**FALCON FIRE PROTECTION DISTRICT**

NEW STATION SITE PLAN

FALCON, COLORADO

NEW STATION SITE PLAN  
FALCON, COLORADO

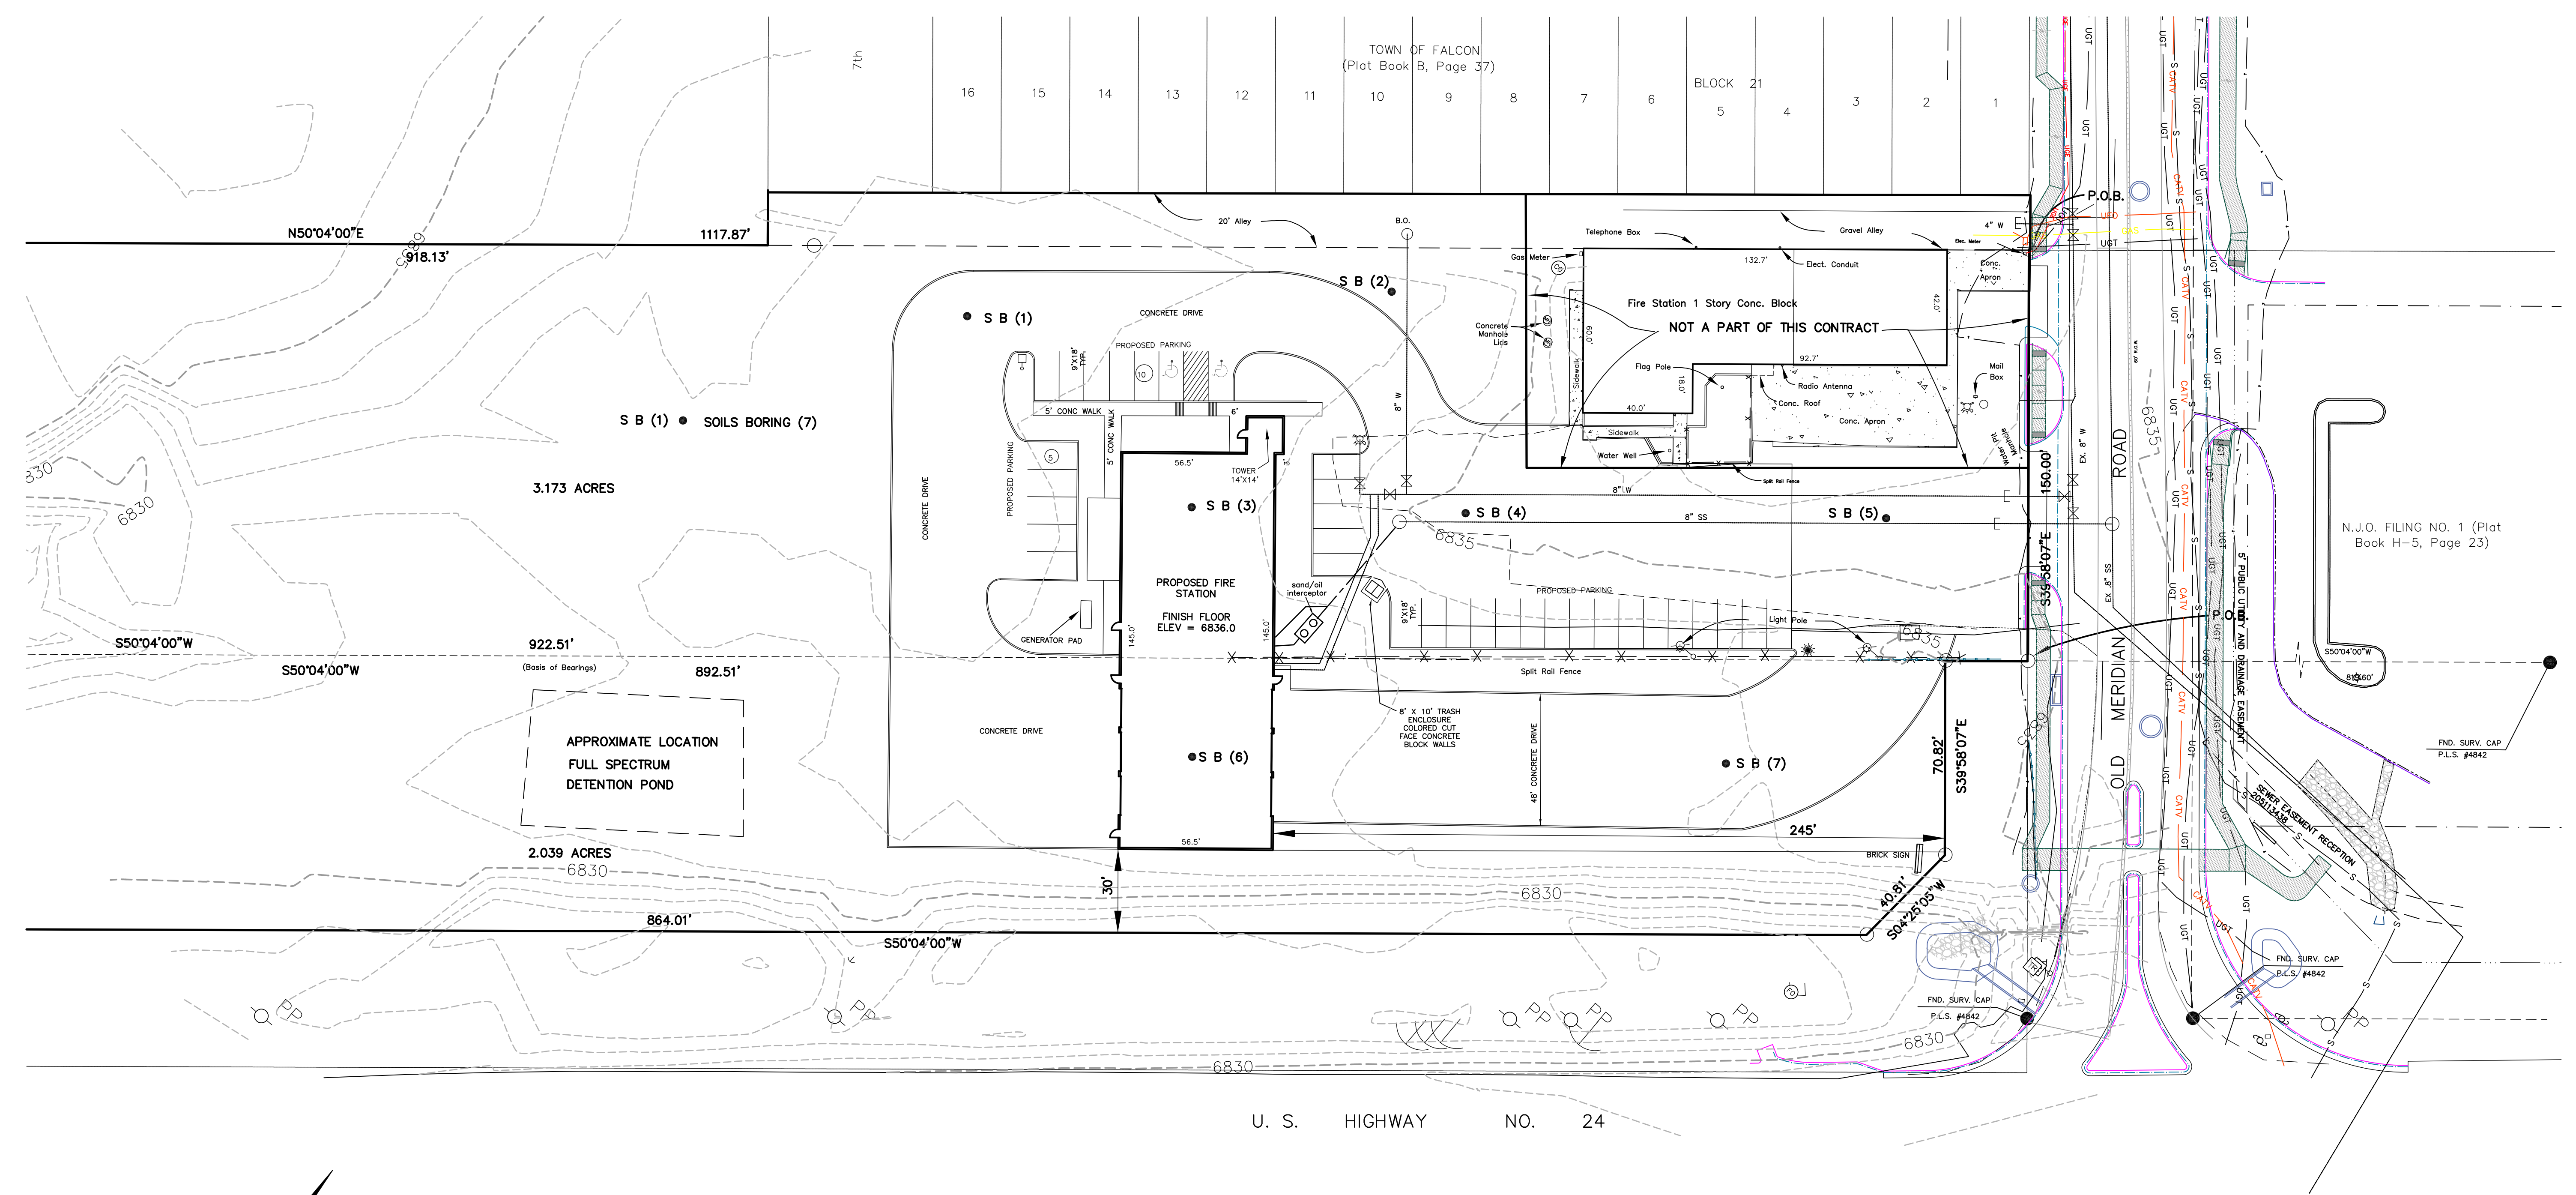
this is only a portion of the overall lot, please show full lot and show this in an expanded detail.

Provide setbacks from property boundaries to the proposed structures.

Ideally show rough landscaping to visualize buffering and screening.
